Re: Residential development with in-fill affordable housing, 16-24 Lord Street & 21-27 Roseville Avenue, Roseville (SSD-78996460)

As a neighbour directly opposite the development, I am writing to formally object to the Hyecorp proposed development of the four 9-storey apartment buildings. This submission outlines serious concerns regarding the inappropriate nature of this development and its significant negative impacts on our established residential community and surrounding heritage conservation areas.

6 2PM - 21 JUNE (WINTER SOLSTICE) - T93

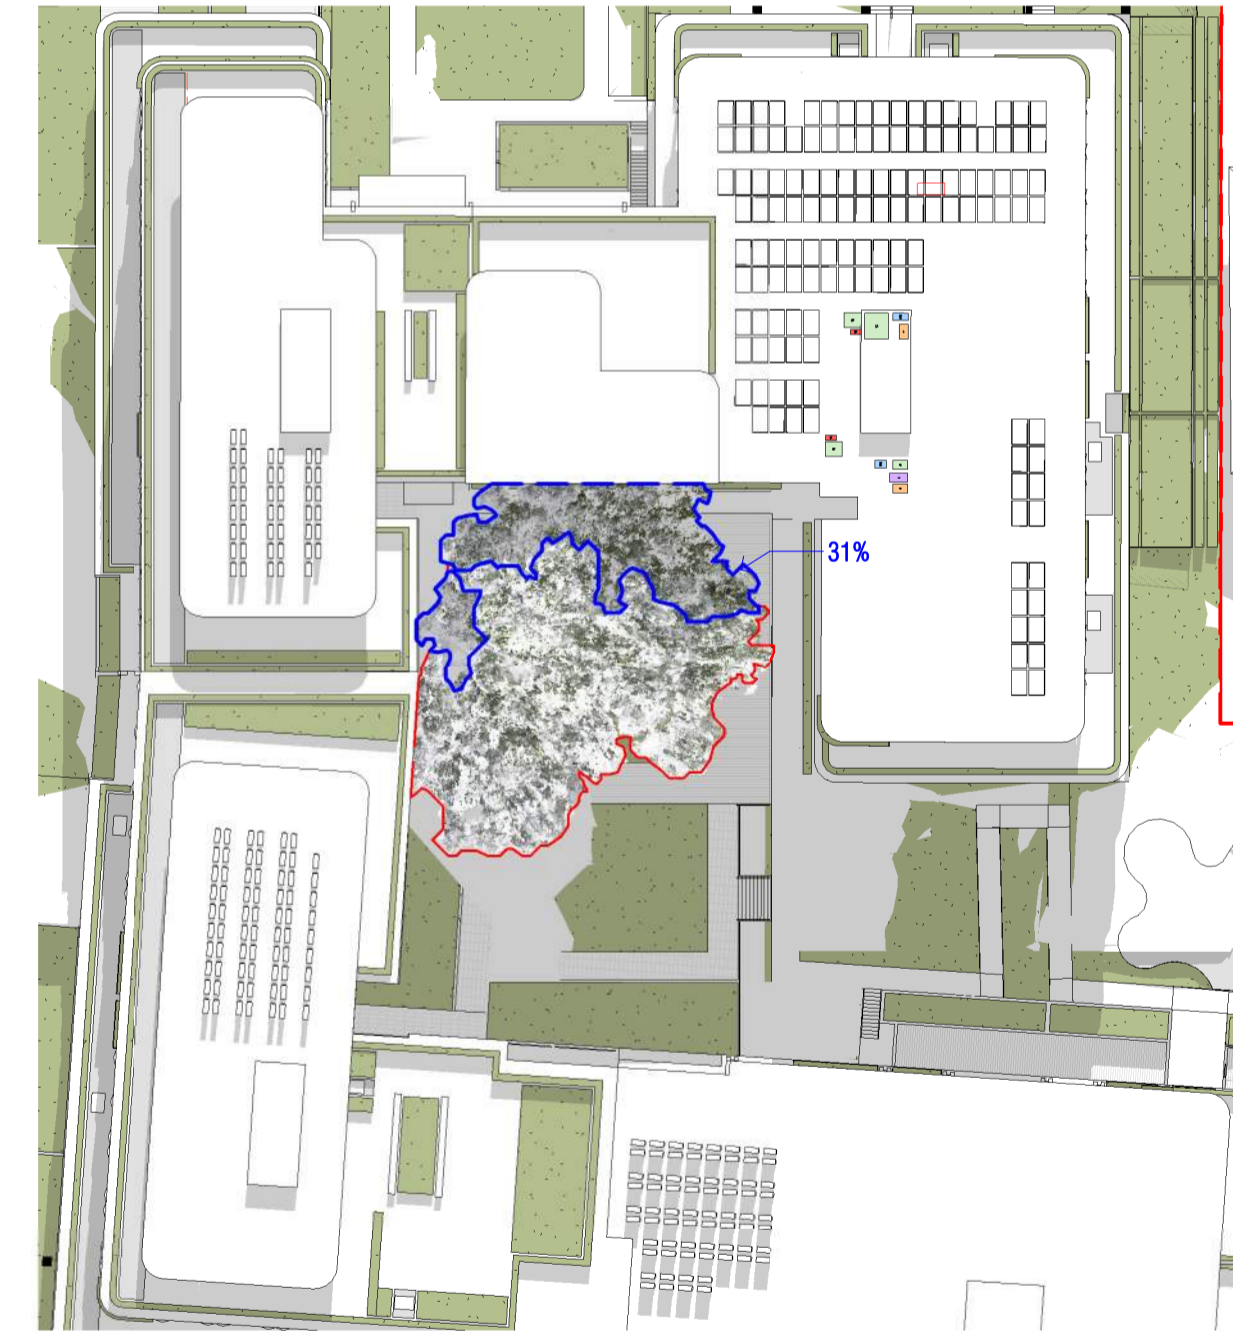
As indicated by section 6.1.2.1 in the EIS document from Hycorp, the proposed building will completely block the north-facing windows of all the houses across the street from 2 PM. This is an extremely unfair burden that neighbouring houses, including mine, have to bear.
